REF: L1041.1 V1

**RE: CLITHEROE AGP  
PEER REVIEW OF NOISE PLANNING SUBMISSIONS  
(PLANNING REF: 3/2018/0372)**

The scheme (Planning application Ref: 3/2018/0372) is a proposal to construct a new artificial grass pitch and the refurbishment of an existing multi-sports area.

Figure 6: Predicted AGP Noise Emission (1.5 metres above the ground).

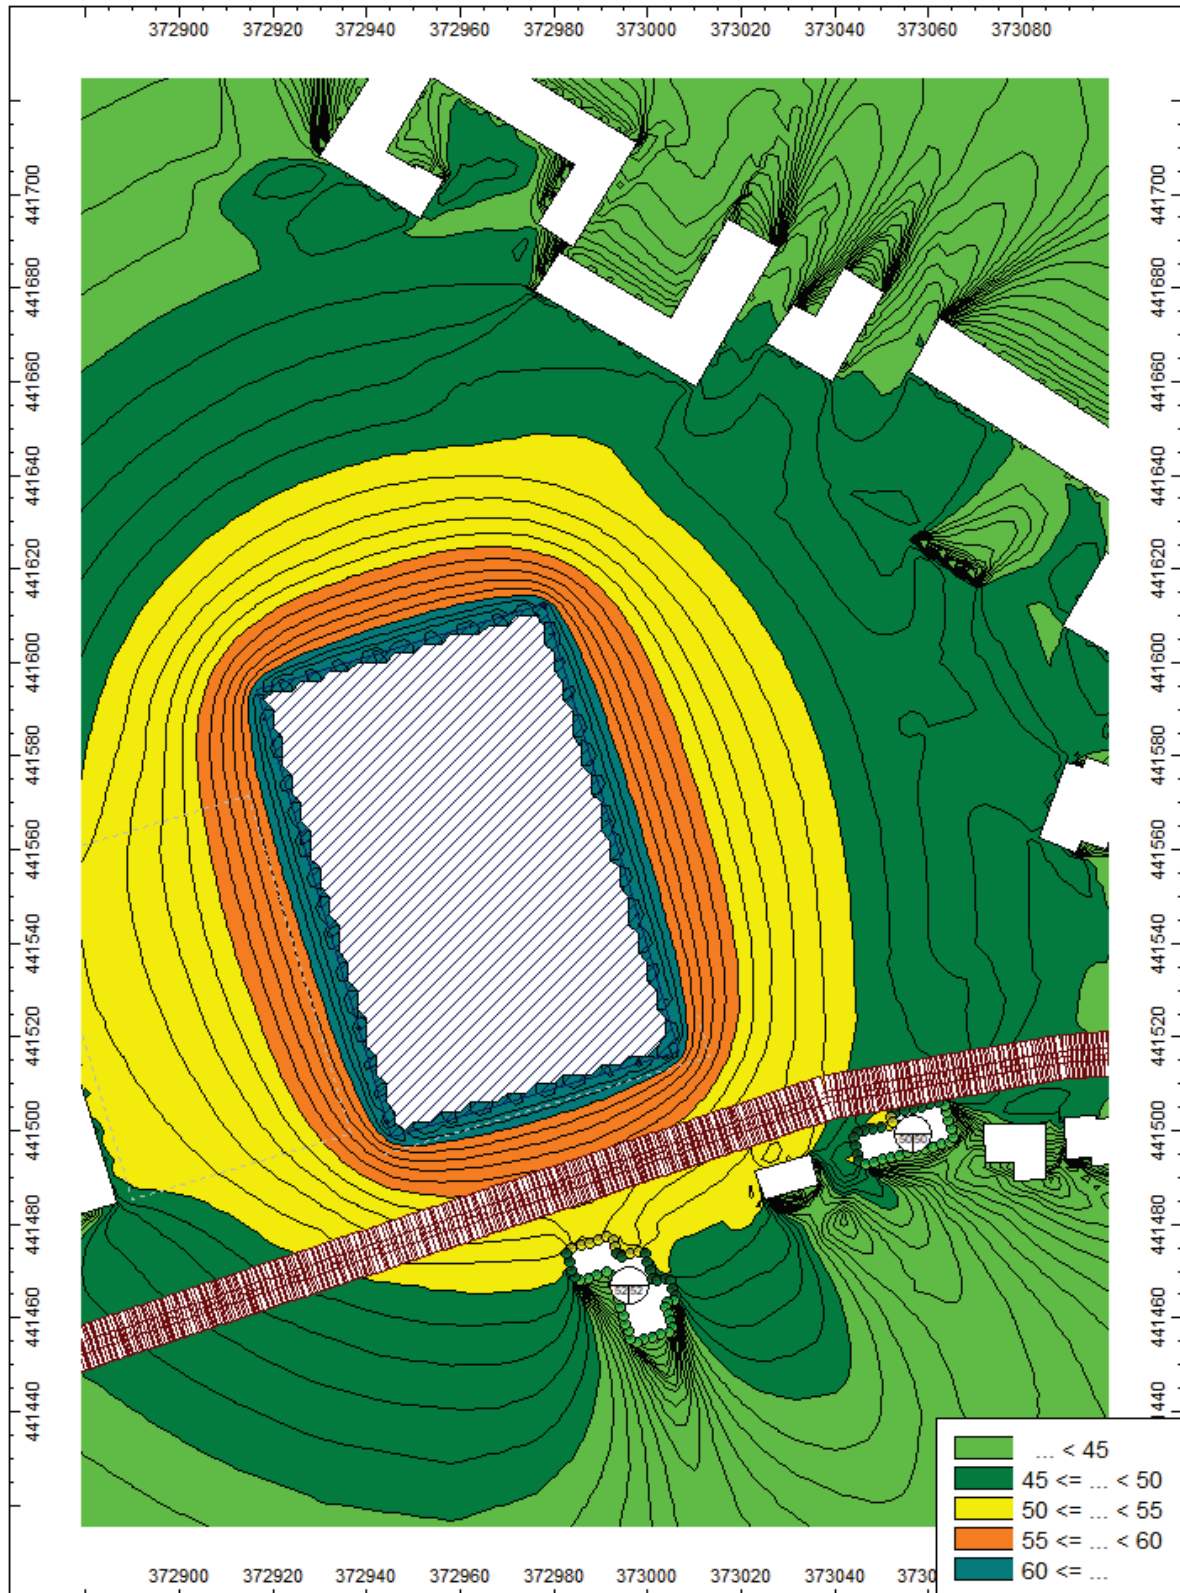
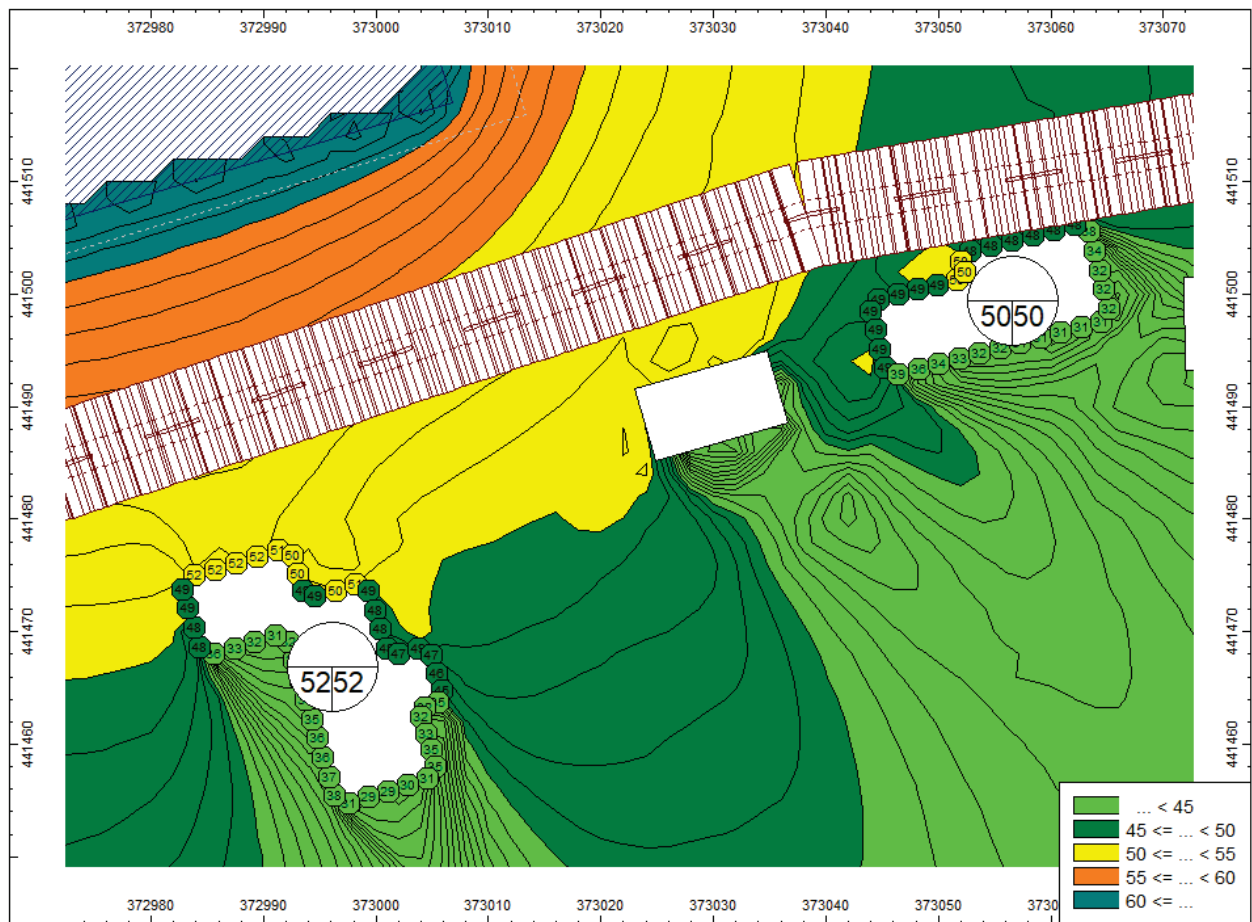
The amended assessment has no barriers around the pitch and has reported the estimated sound at Ann's Square to be 47 dB(A)  $L_{Aeq,1hour}$ . The calculations therefore confirm that the screen does not concentrate sound towards the properties in a North-Easterly direction, and which should alleviate the concerns raised by the EHO (Mr Alan Taylor) stated in his consultation response of 21<sup>st</sup> May 2018.

The amended assessment indicates sound levels of 52 dB(A)  $L_{Aeq,1hour}$  at the nearest property to the South across Edisford Road, to the South of the proposed AGP. The benefit of the barrier from the first assessment can therefore be concluded to offer a notional reduction of around 5 dB(A) from the sound generated on the new AGP. The estimated levels without the barrier do not satisfy the derived target values although we note that the excess is limited only to this property and the excess is small at 2 dB(A).

Within the submitted assessment, the point is also made regarding the location of opening windows on the nearest property to the South being on elevations which do not face the proposed AGP. Further calculations are provided which indicate the facades where there are windows would be exposed to levels of up to 49 dB(A)  $L_{Aeq,1hour}$ , and which therefore achieve the target level. The reduction of circa 3 dB for a façade that is perpendicular to a source correlates with our experience of how sound levels change around buildings. The derived basis of assessment fundamentally relies on the attenuation through an open window and in our opinion the targets should only be applied to facades which have opening windows.

With the information available we are of the opinion that the barrier is not required to the AGP.

Figure 6: Predicted AGP Noise Emission (1.5 metres above the ground).

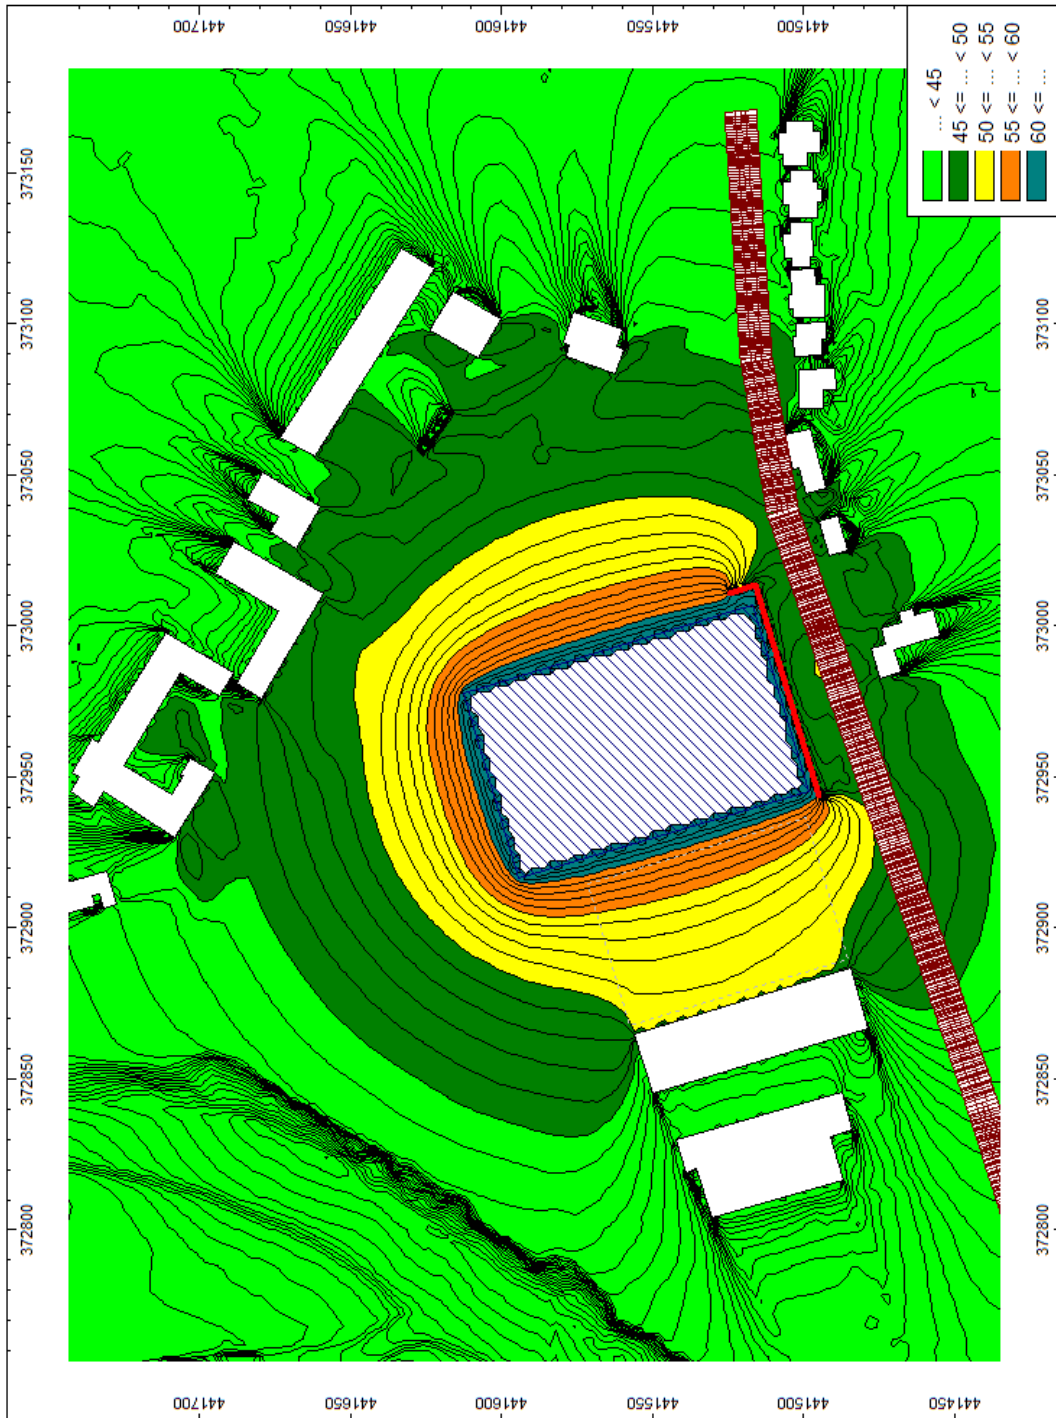
The original assessment has included a 3.5 m high barrier to the Southern side of the proposed pitch. With the barrier the calculated levels at the nearest properties are reported to be 47 dB(A)  $L_{Aeq,1hour}$  which achieves the derived basis of assessment with a margin of 3 dB(A).
